**Planning Application BR/21/13 –
Land Adjacent to No 6 Seafield Terrace**

With reference to the above Planning Application for the erection of a 3-bedroom house on land adjacent to No 6 Seafield Terrace, I should like to put forward my reasons for opposing this development.

Floor Plan – Ground Floor
Proposed
1:50
BCG 1
06.02.2013

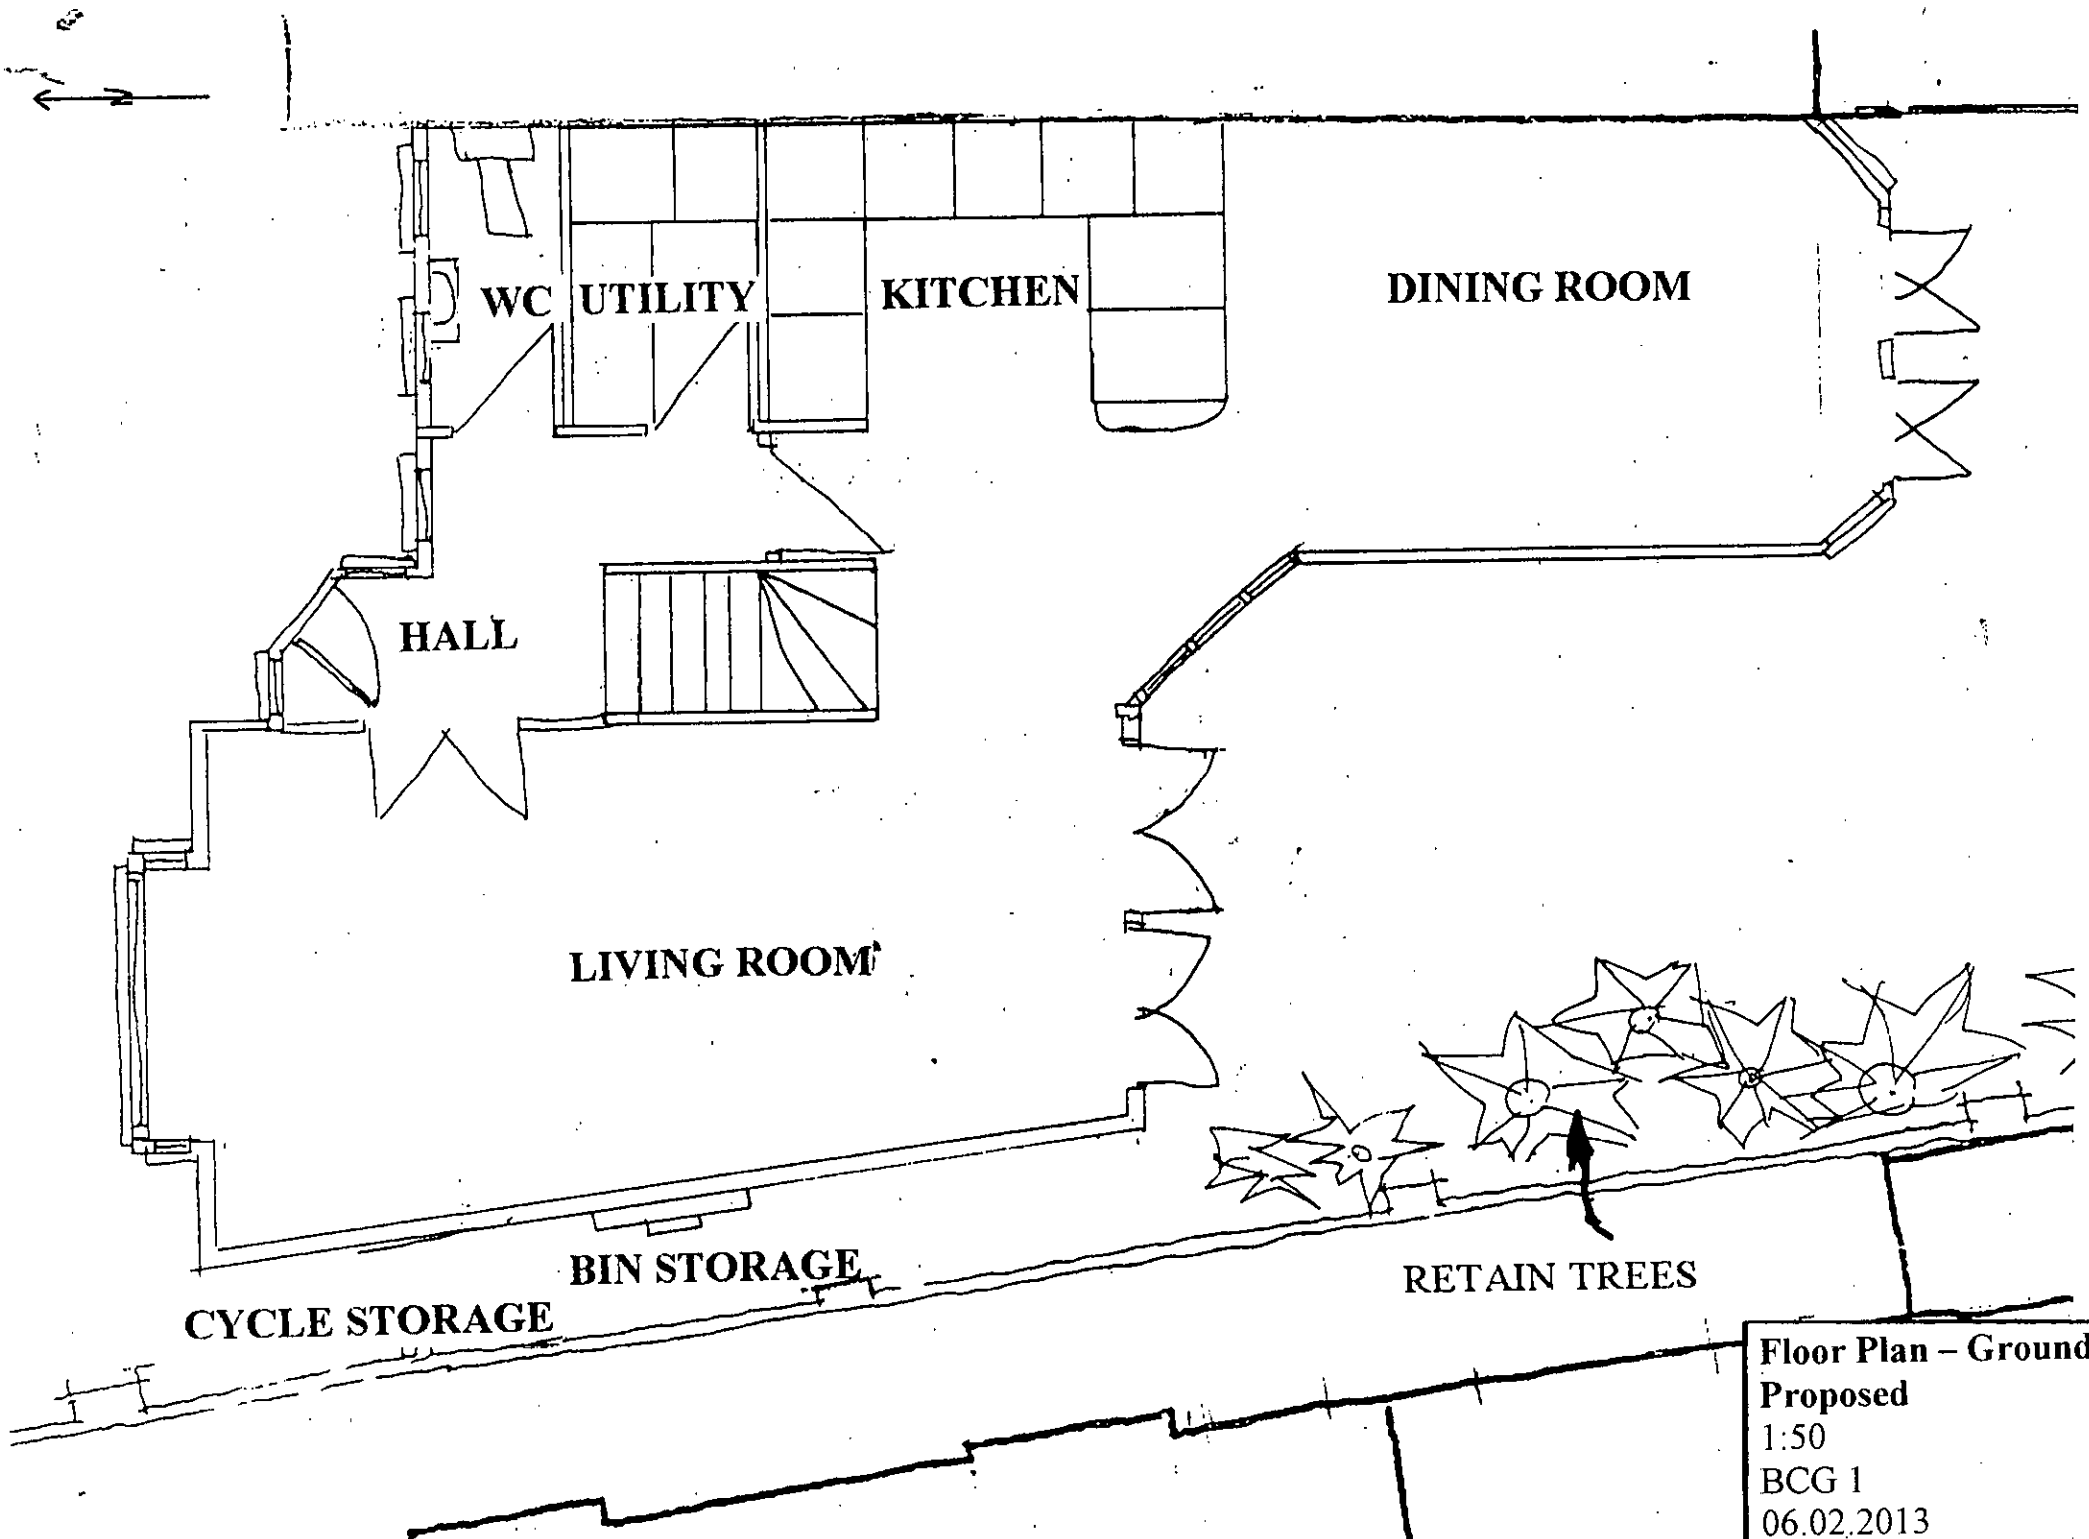
Parking is a major problem along all of Stocker Road. There is not adequate parking for the residents of Stocker Road, which is constantly used for parking by vehicles associated with local businesses. The plans do not include a garage, which I consider is essential to any development of this land.

Floor Plan – Second Floor
Proposed
1:50
BCG 1
06.02.2013

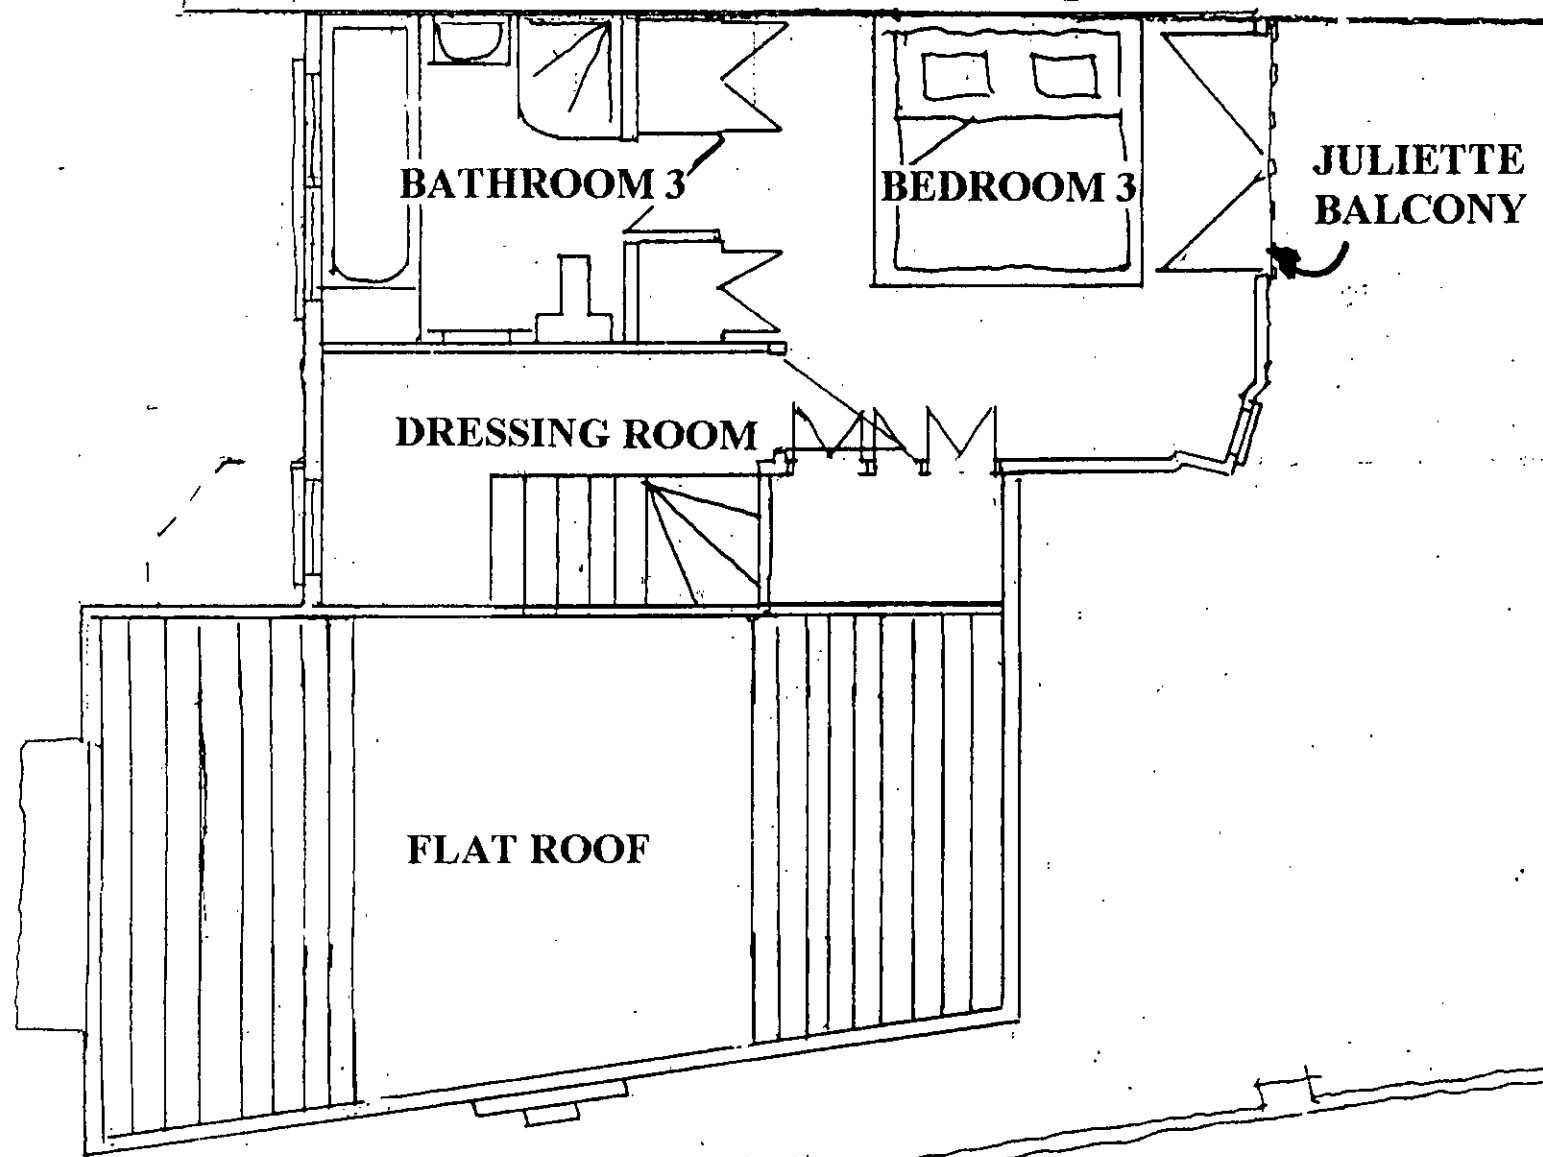
I am very concerned that the proposed house will have a negative impact on the privacy of neighbouring properties at 3 Stocker Road and the flats opposite to the south. The proposed Juliette balcony at the second floor bedroom will be particularly intrusive and affect the privacy of facing and adjacent properties. I appreciate that No 1A Seafield Terrace has a balcony at this level but it also has an uninterrupted view to the sea and the situation is not comparable.
